Recommendation Report for Planning Permission for Works or Extension to a Dwelling

REF NO: P/102/18/HH

LOCATION: 26 Sea Lane
Pagham
PO21 4UL

PROPOSAL: Single storey side and rear extension

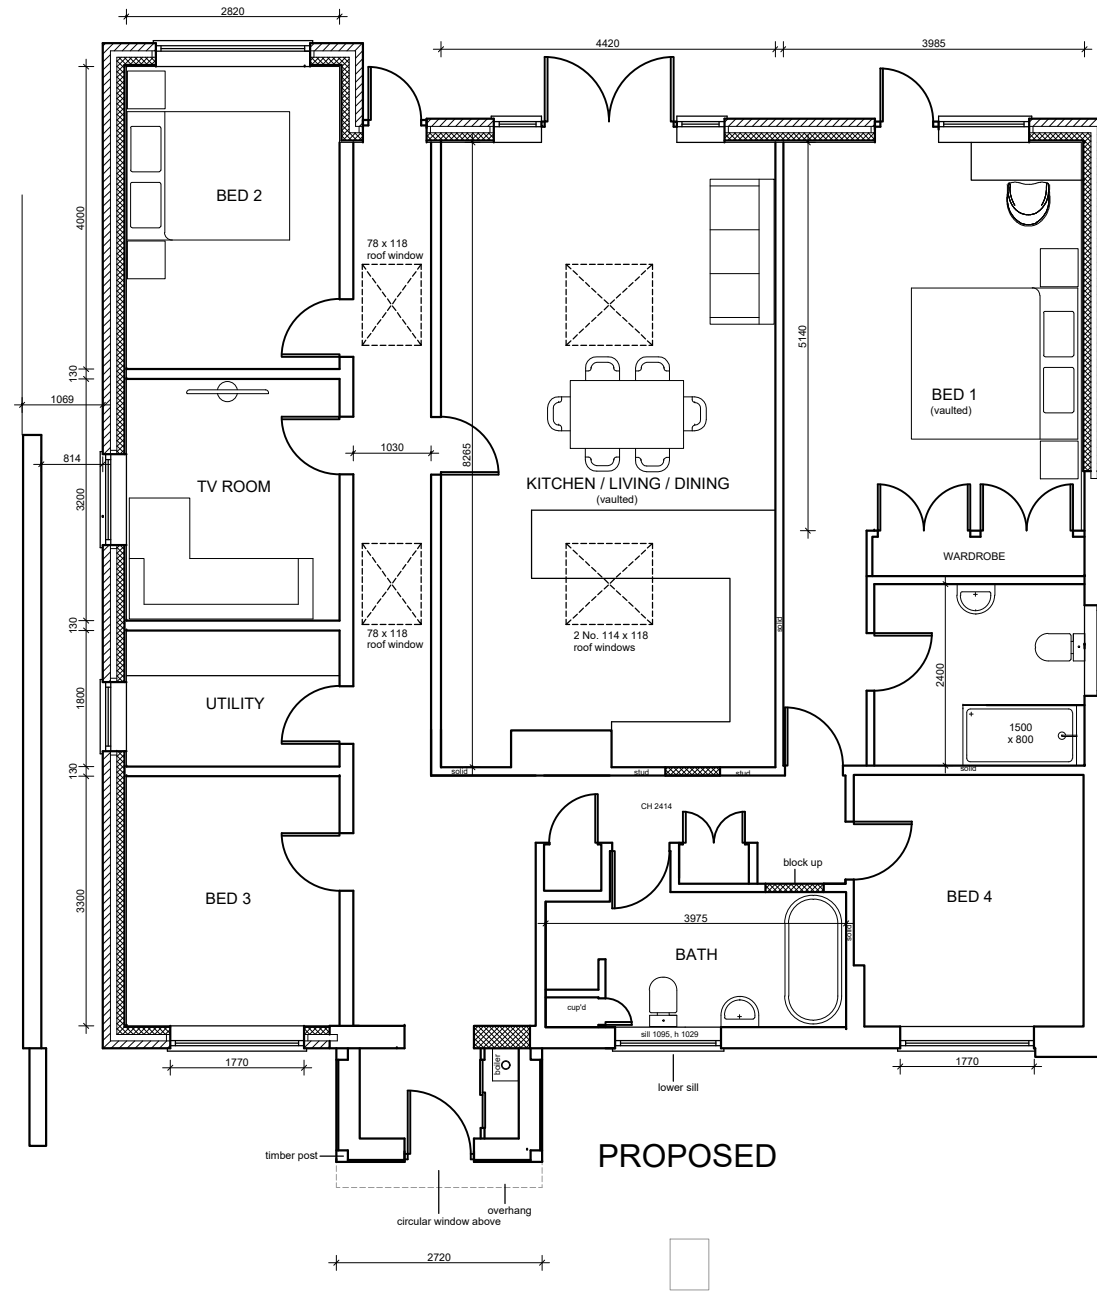
At the rear of the dwelling there is an existing conservatory of depth 2.6m which will be removed. The proposed extension will run the full width of the rear and increase the overall depth of the dwelling by around 4.7m, however to the south east boundary there is also a gable projection and therefore it will extend 5.7m. The roof to the rear of the property will alter its pitch and slope the full depth of the dwelling and extension. The height of the rear of the dwelling will therefore increase. Where its existing eaves are at 2.6m the height of the dwelling at this point will increase to 4m, with it reducing to 2.6m in height at the rear of the extension.

There will be 4 velux windows installed to the rear roof slope however these will not give rise to any overlooking due to their siting above finished floor level. A set of doors and windows will be installed to the rear however at single storey views are not considered to increase from that which are already possible. There will be 2 windows installed to the south east elevation and due to their siting views are likely to be of the boundary treatment and neighbouring garage and therefore not likely to give rise to any significant overlooking. The window to the north west elevation again due to its siting is not considered to give rise to any significant overlooking upon neighbouring amenity.

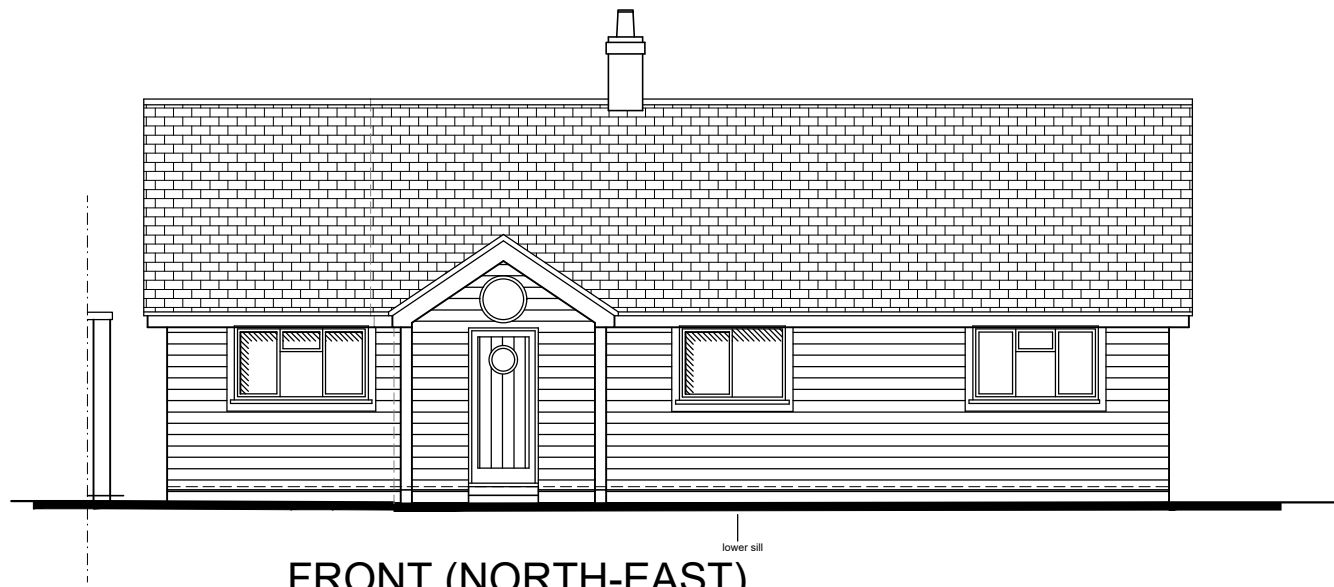
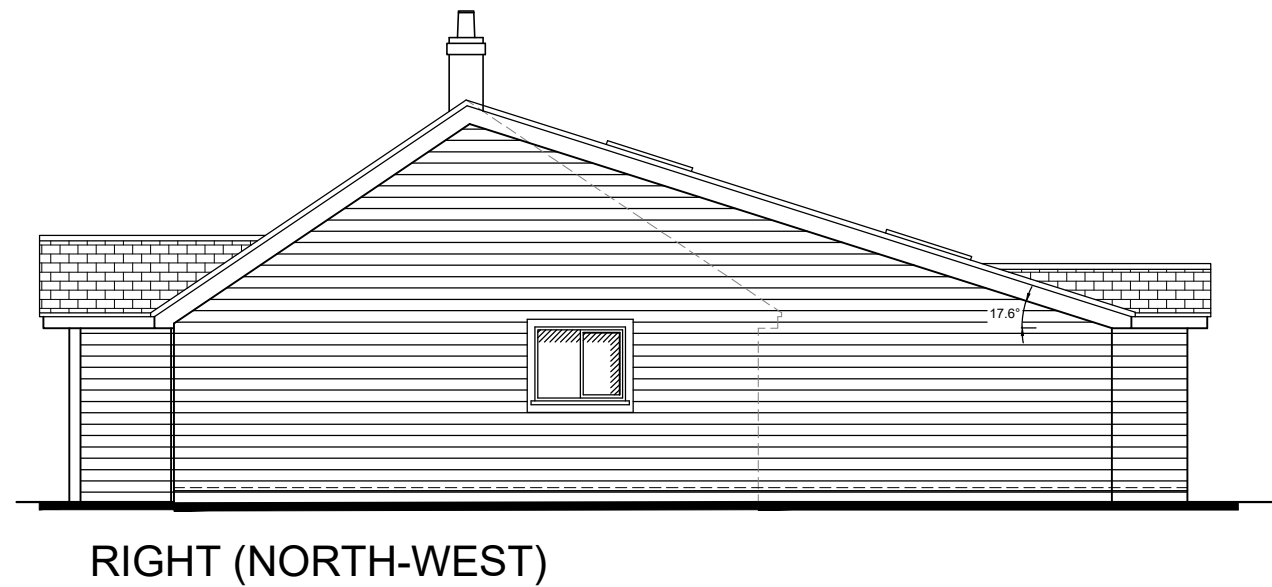
A porch will be constructed to the front with a gable roof, with similar examples of porches within the surrounding area. Cladding is also proposed which is present in a number of properties. Due to the mix of housing types and designs the proposal is not considered to be out of keeping with the area.

The porch extension to the front will have a modest depth of 1.45m and a width of 2.75m and therefore does not appear overly dominant or overbearing. The garage at present has a flat roof however this is to be demolished and a pitched roof will be constructed to the side addition to match the existing dwelling. Due to its siting, the alteration is not considered to give rise to a loss of light or appear overbearing upon No 28.

therefore appear overbearing. However, as it is a bungalow property and the height decreases towards the rear it is not considered to give rise to a significant overbearing impact. Additionally, the property to the west at No22 extends to the same distance as the proposed and therefore its rear elevation is in line with other nearby neighbouring properties. With sufficient boundary treatment in place at the south east boundary and the separation distance increased to 1m, the development is again not considered to appear significantly overbearing.
